DEVELOPMENT REVIEW BOARD

Parks and Recreation Department

PR-2021-005573

REQUEST: AN APPROXIMATELY 117.53 ACRE EXPANSION OF THE EXSITING ALBUQUERQUE STUDIOS CAMPUS INCLUDING A NEW PRODUCITON OFFICE, MILL BUILDING AND PRODUCTION SUPPORT SPACES.

**OVERALL
ALTERNATIVE
LANDSCAPE PLAN**

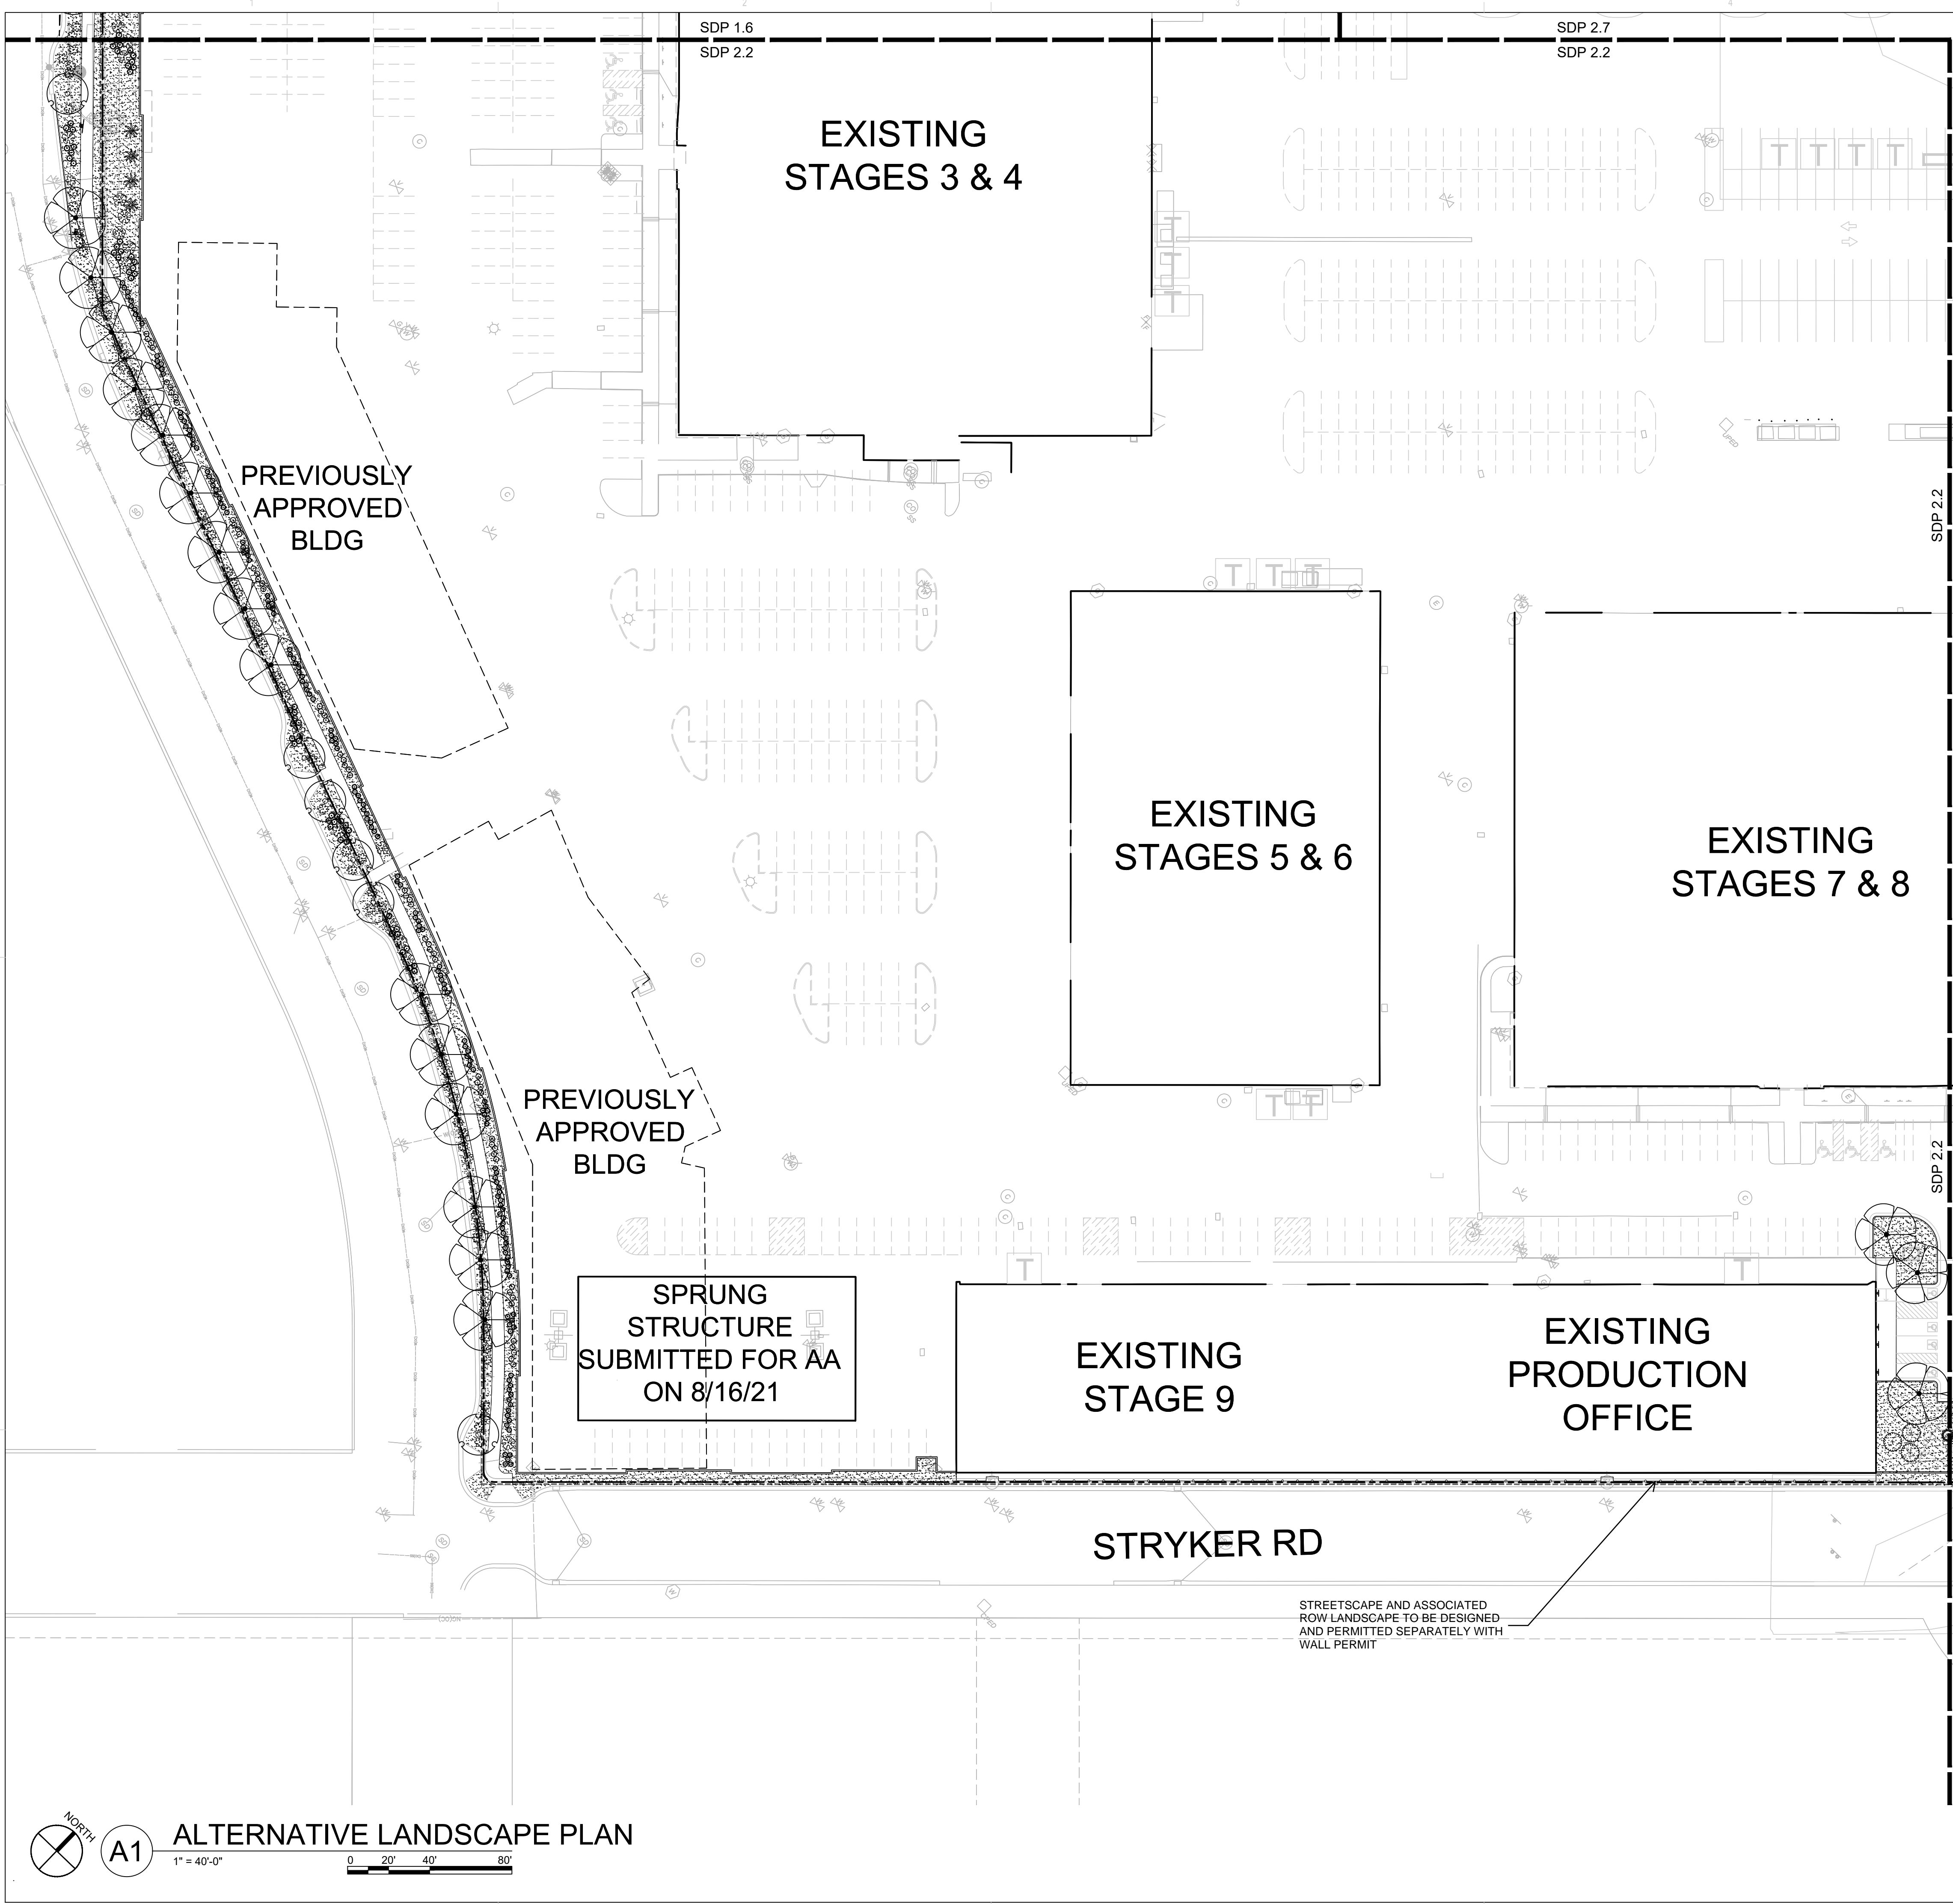
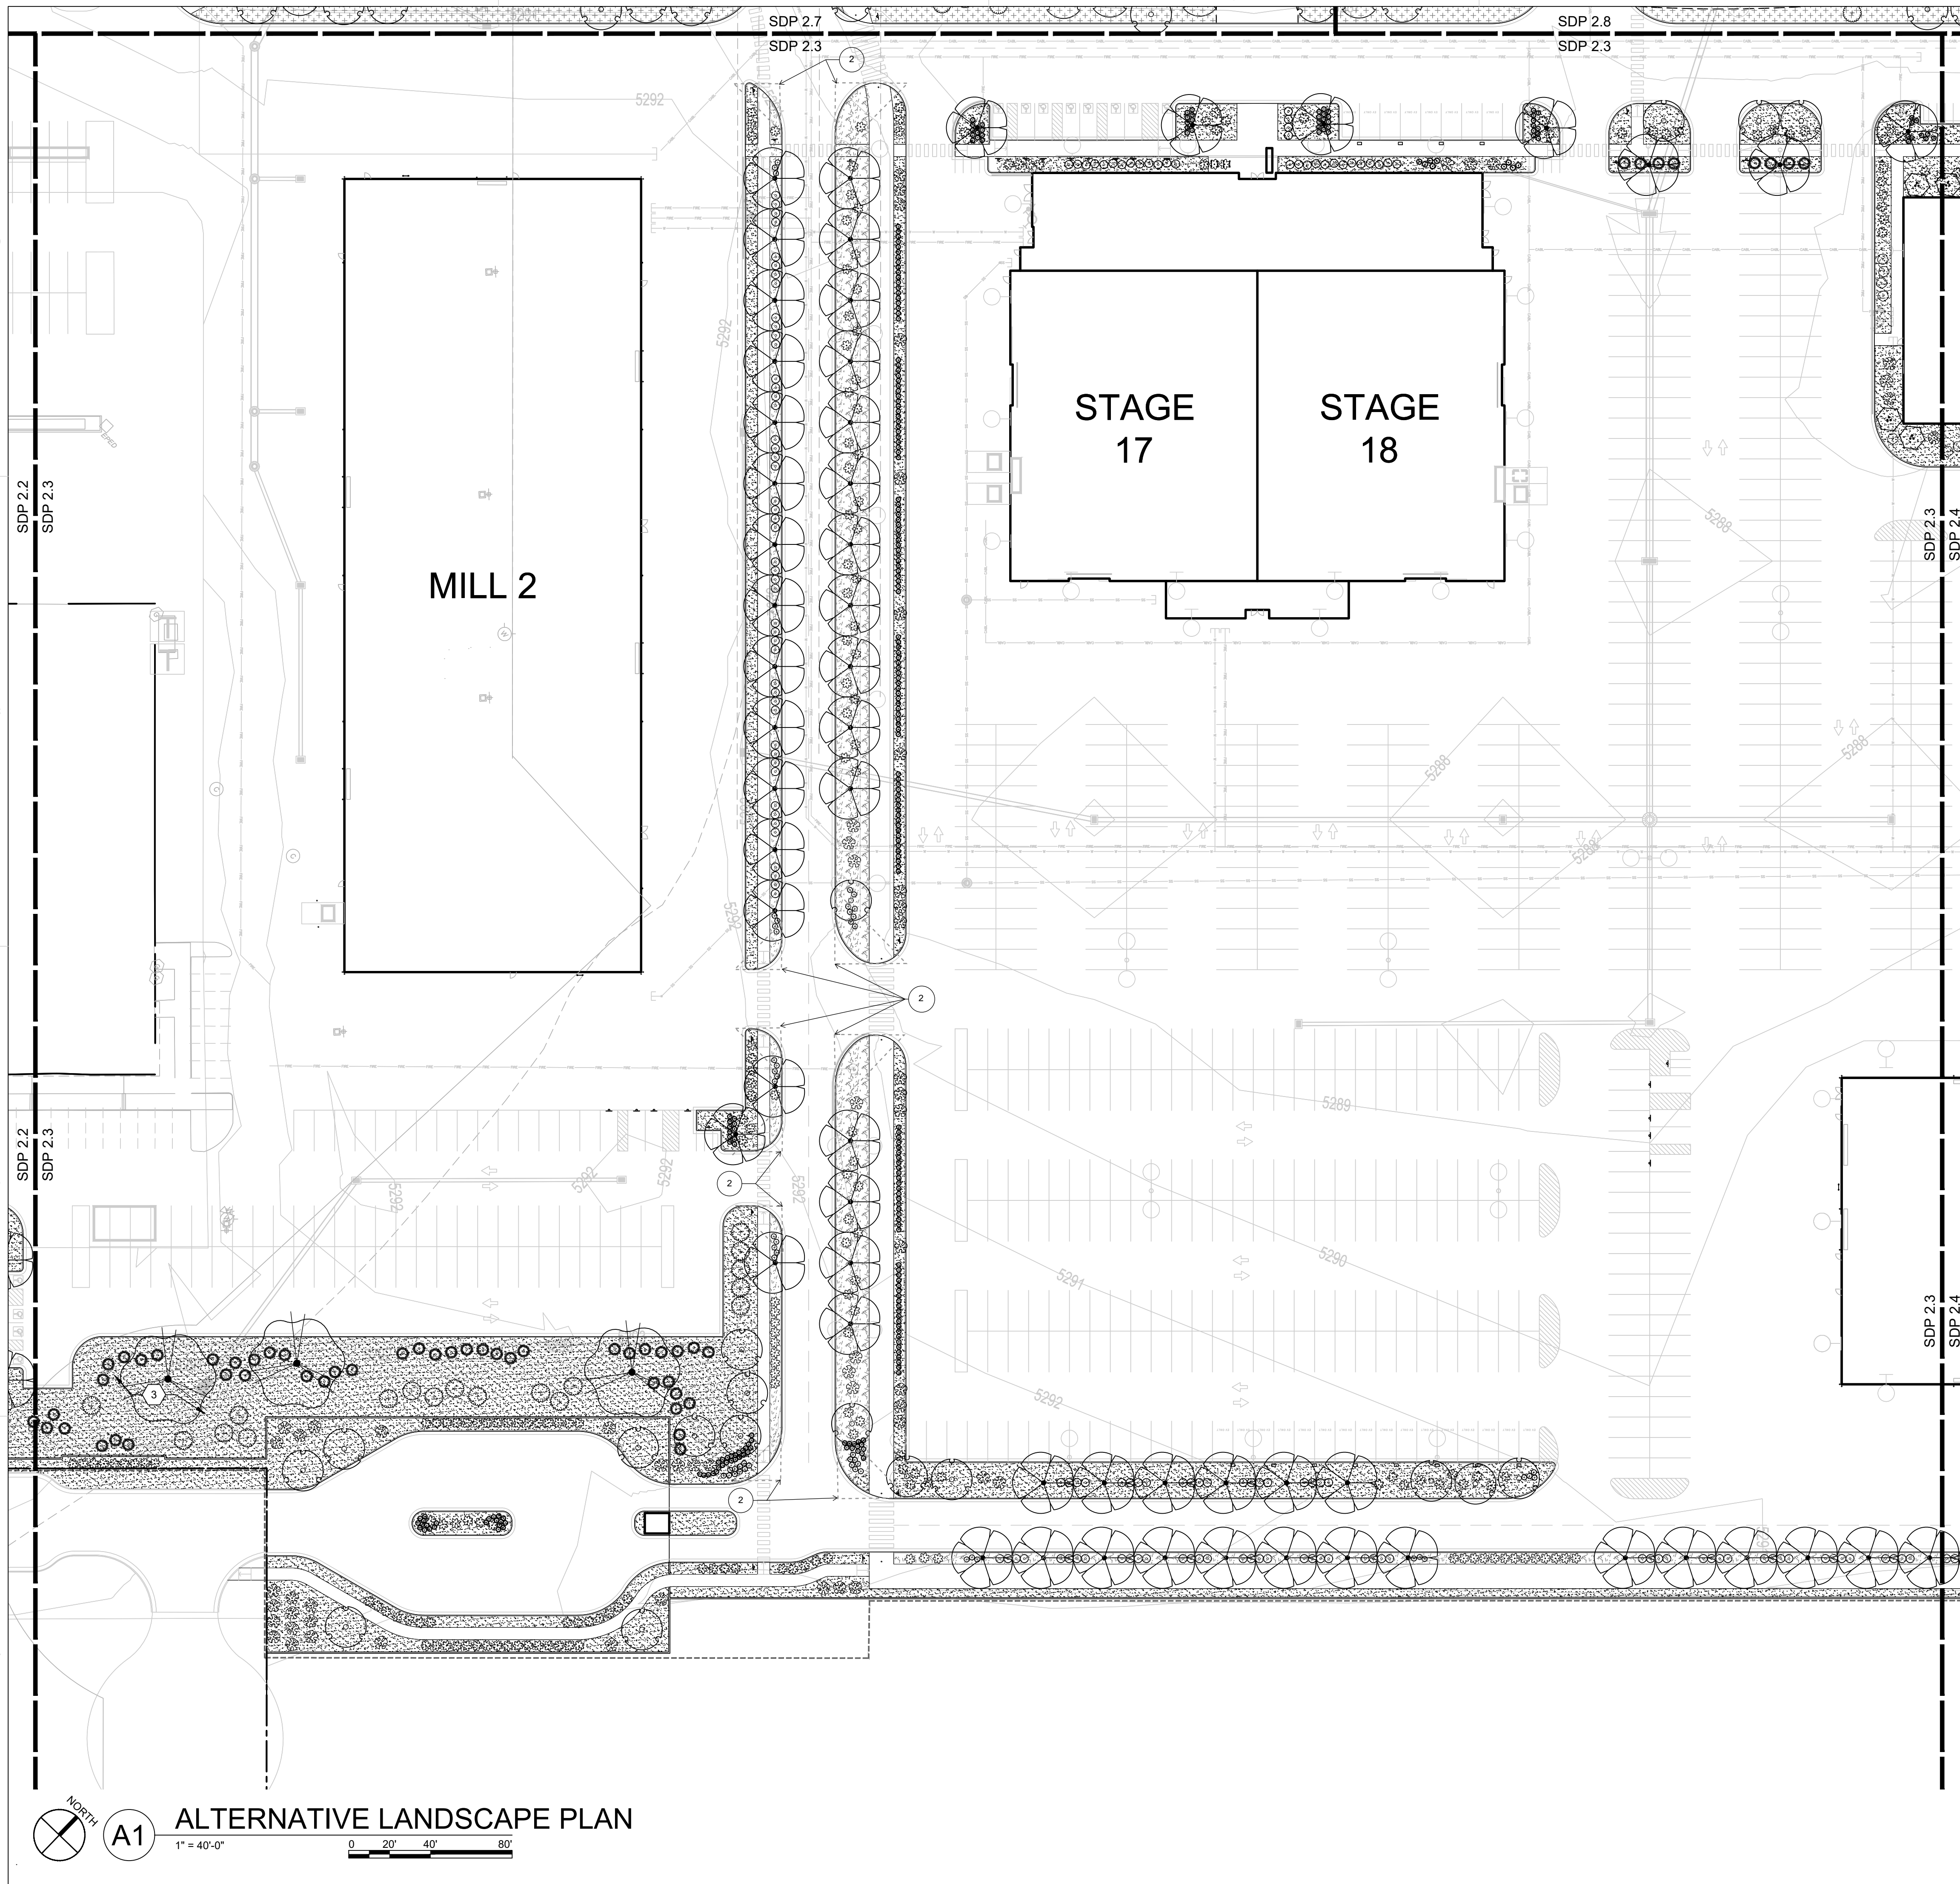
Is the plant pallet derived from a Mesa del Sol list? – if so, please provide referenced master list and/or page along with list for native seed mix. Where rock mulch used, please provide note regarding wood mulch for trees per 5-6(C)(5)(e).
